Application for a non-material amendment following a grant of planning permission. Town and Country Planning Act 1990

House:	97	Suffix:	
House name:			
Street address:	Barnham Road		
Town/City:	EASTERGATE		
Postcode:	PO22 0EQ

Alterations to Eastergate Rectory (No 97) and the erection of 3 No. Dwellings with associated access, parking, landscaping, amenity and refuse provision.

Drg No: 1220/13/P/06B

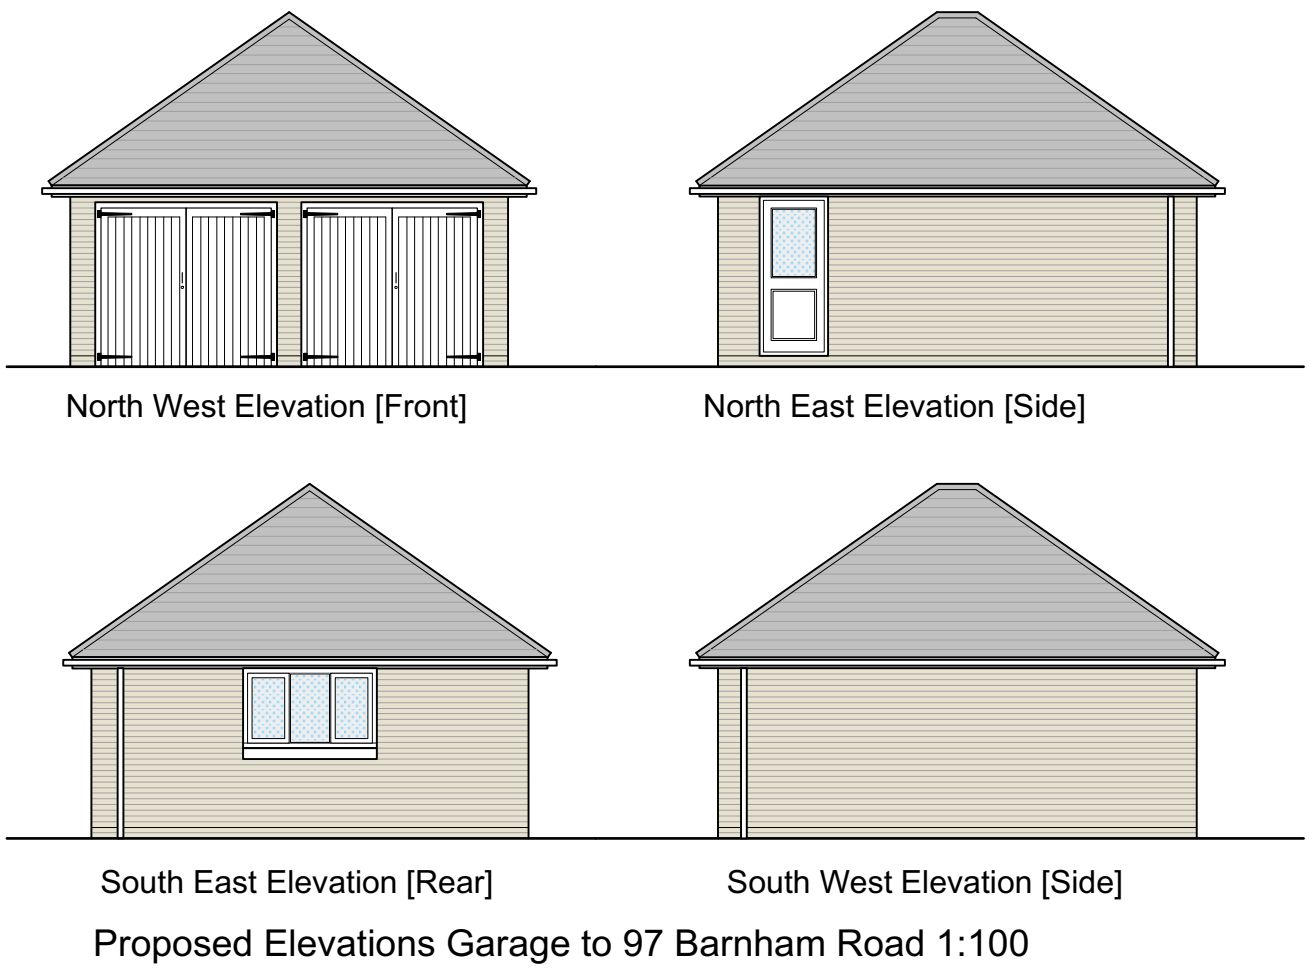
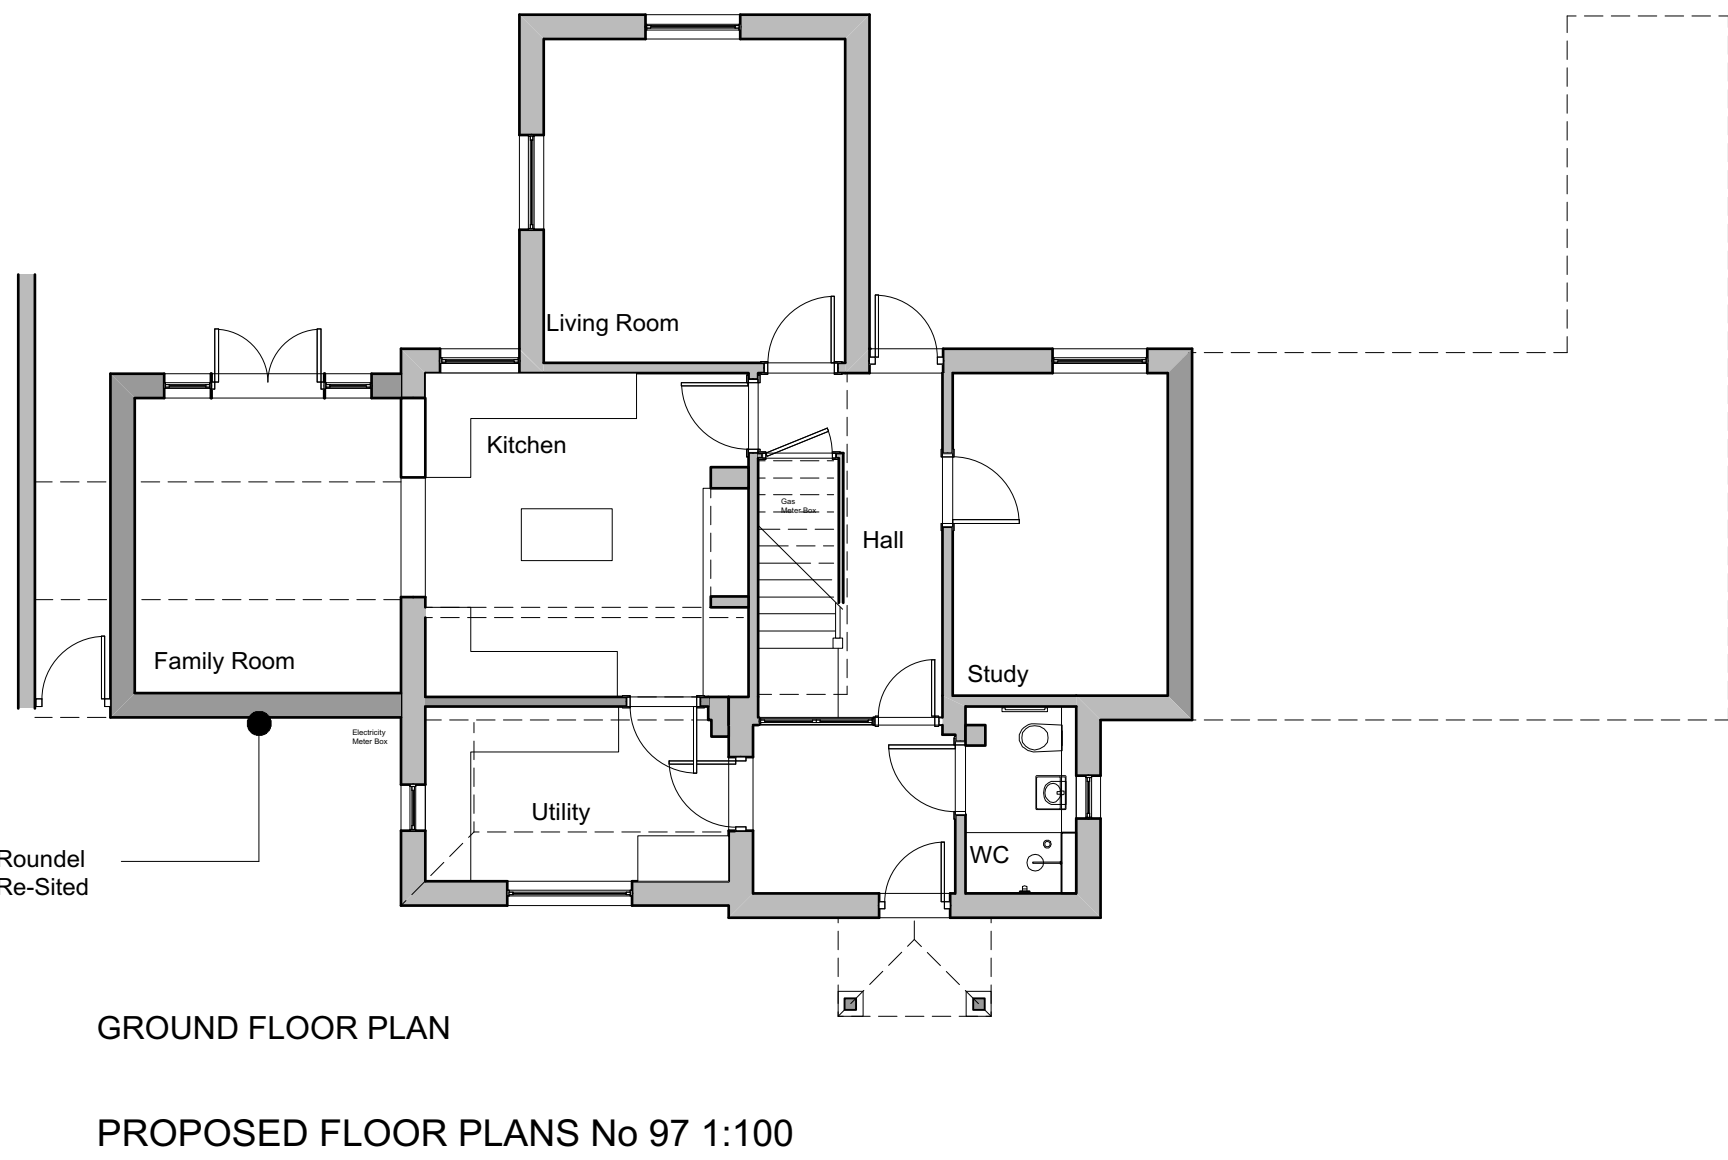
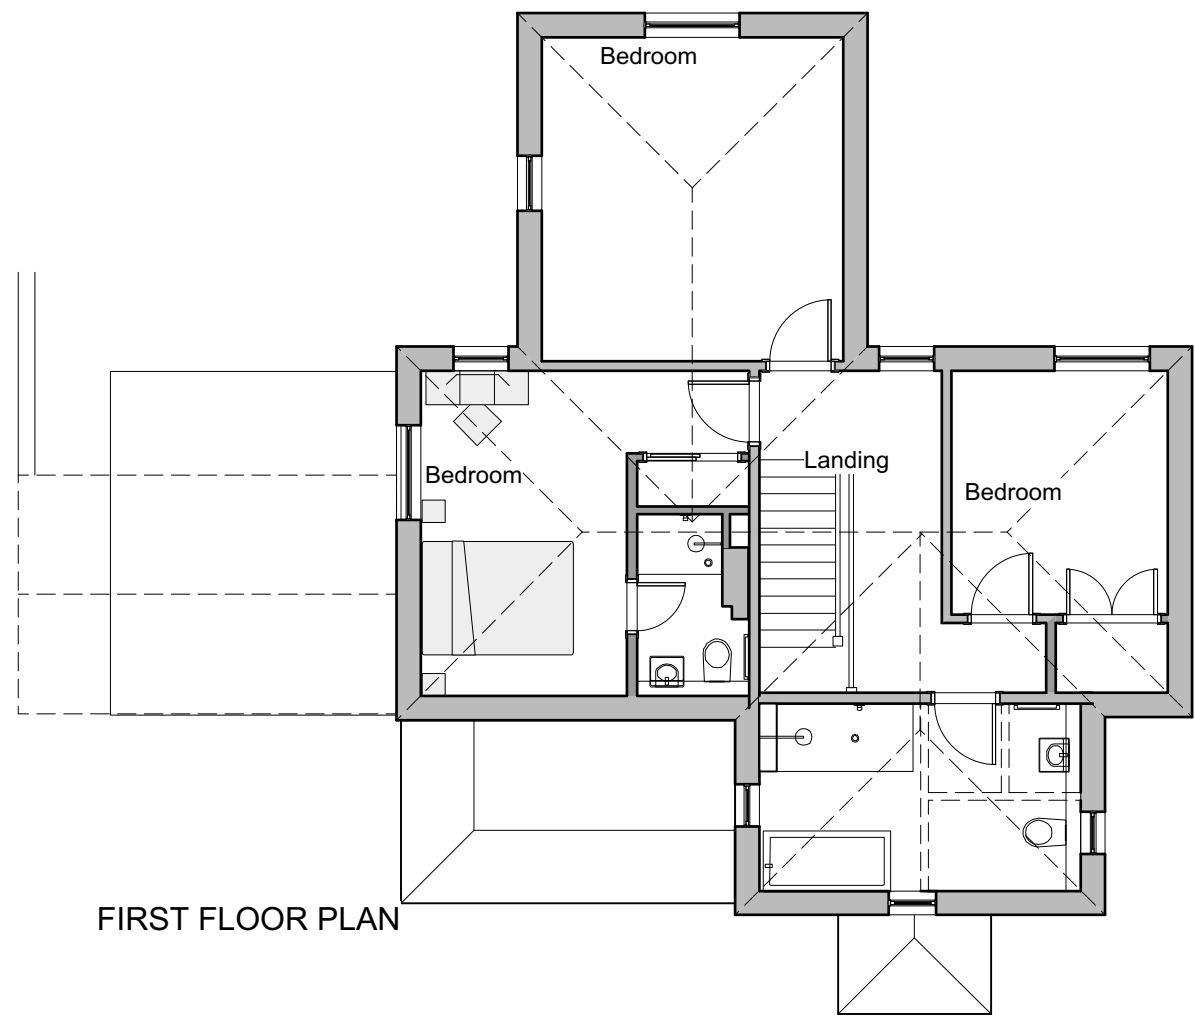
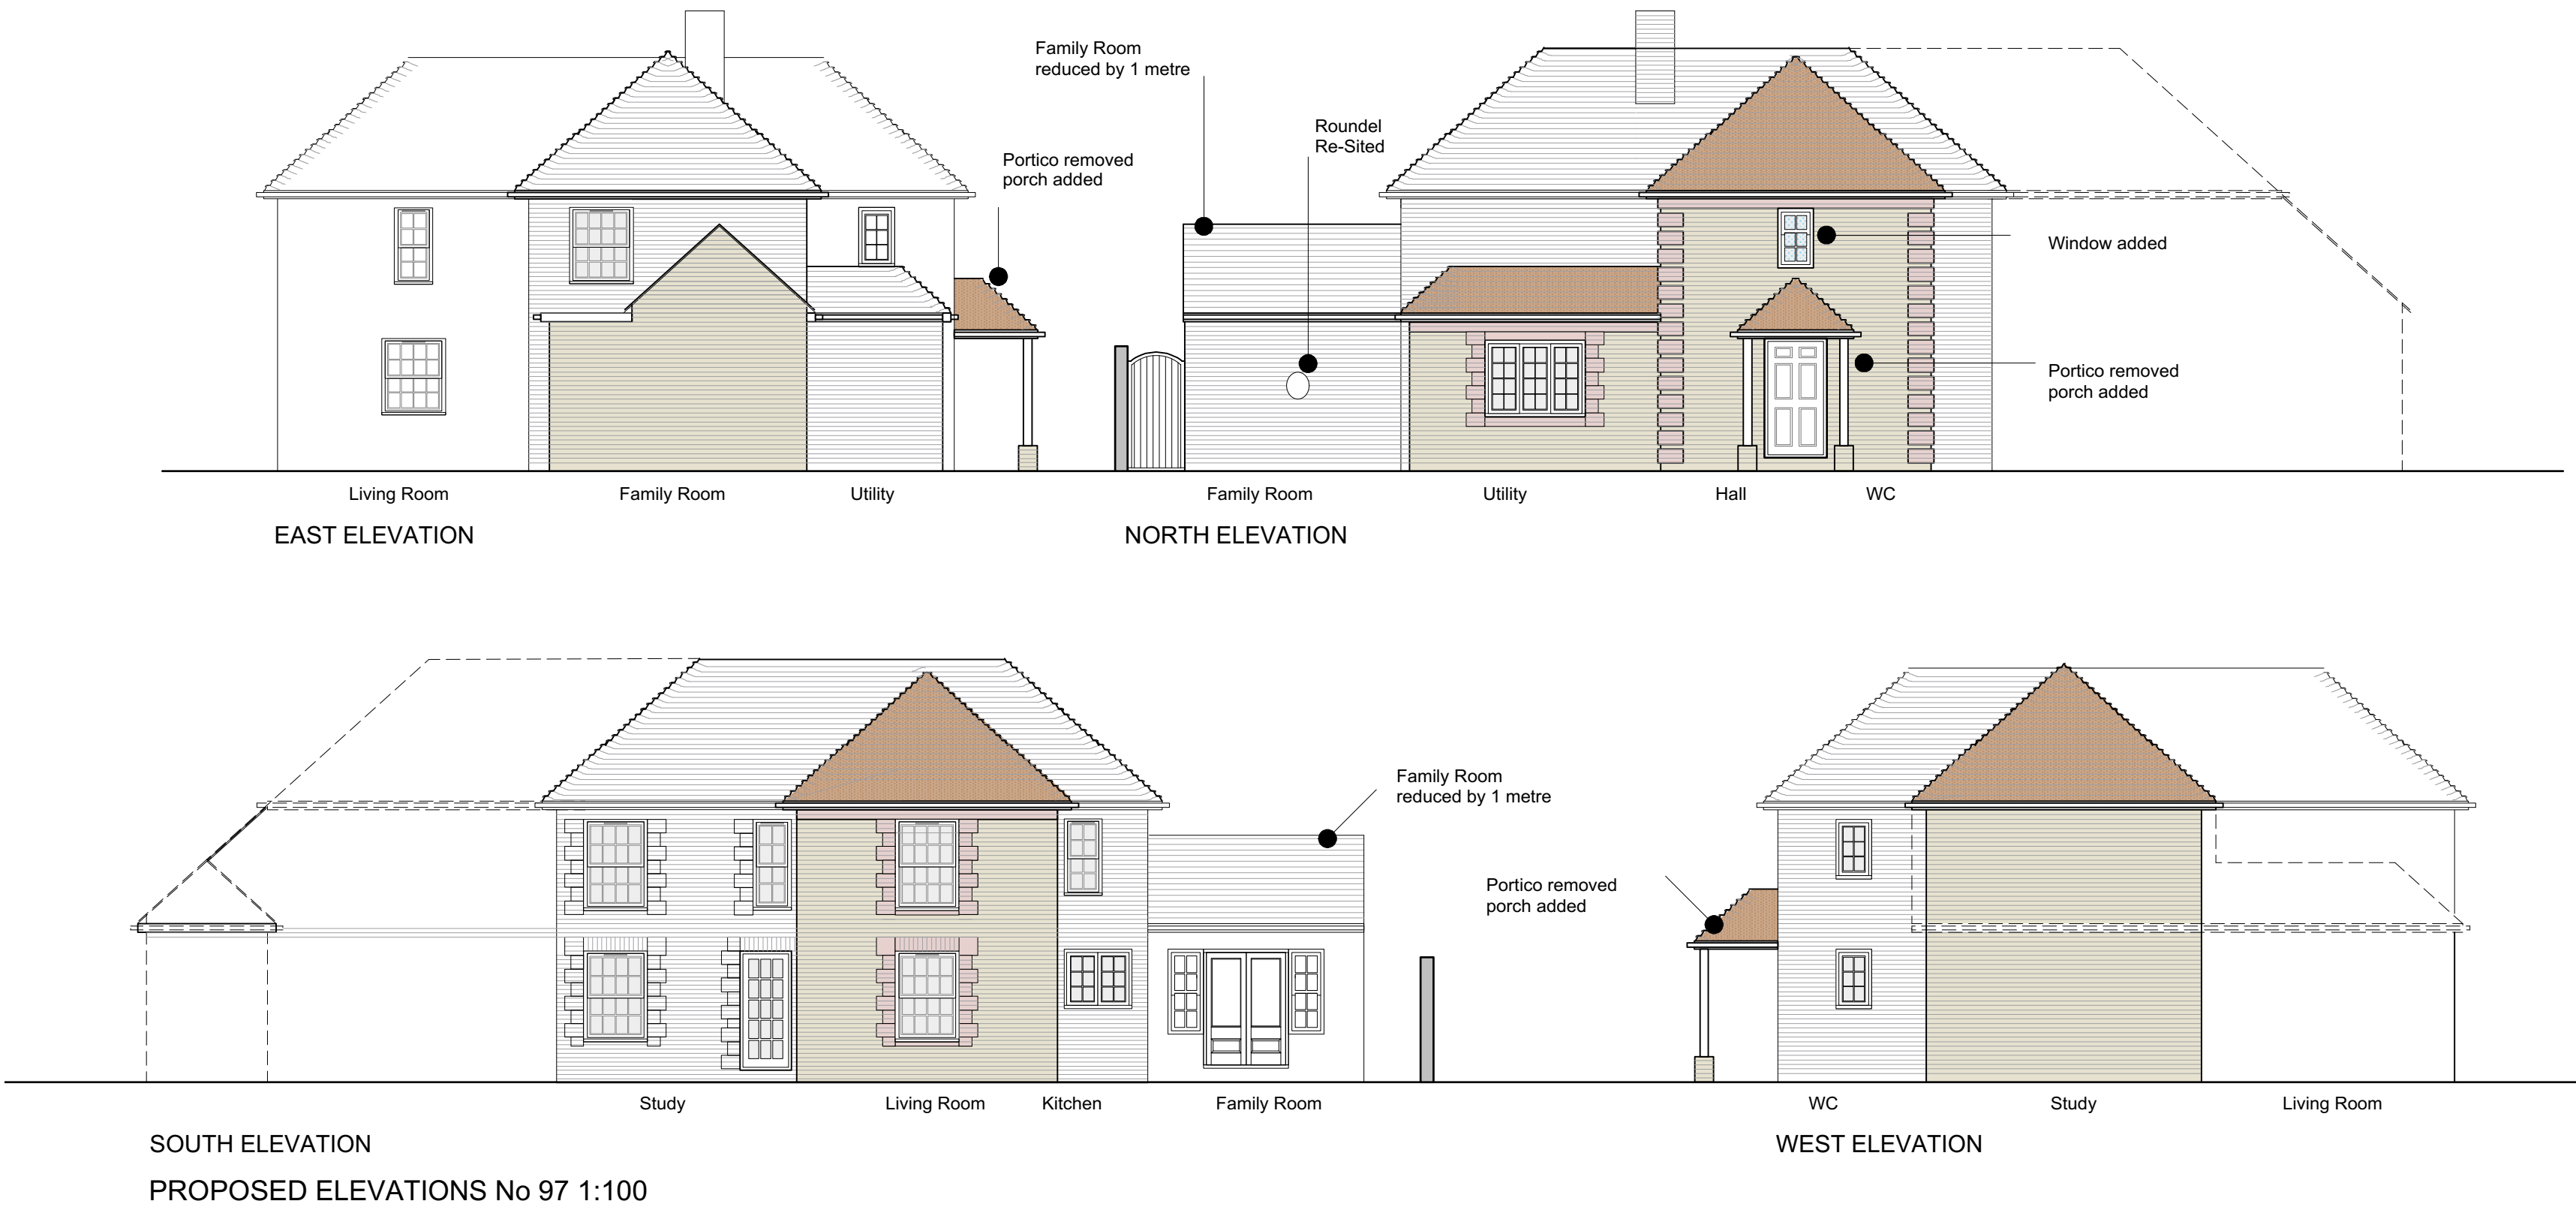
Firstly, to reduce size of single storey side extension to south east elevation to leave a separation distance of one metre from the adjoining property.

Secondly, to add an additional window to the principal elevation at first floor level to serve a bathroom. The decorative roundel will be re-sited within the blank facade to the side extension.

Provide secondary access to the rear garden, to provide natural light and ventilation to a family bathroom.
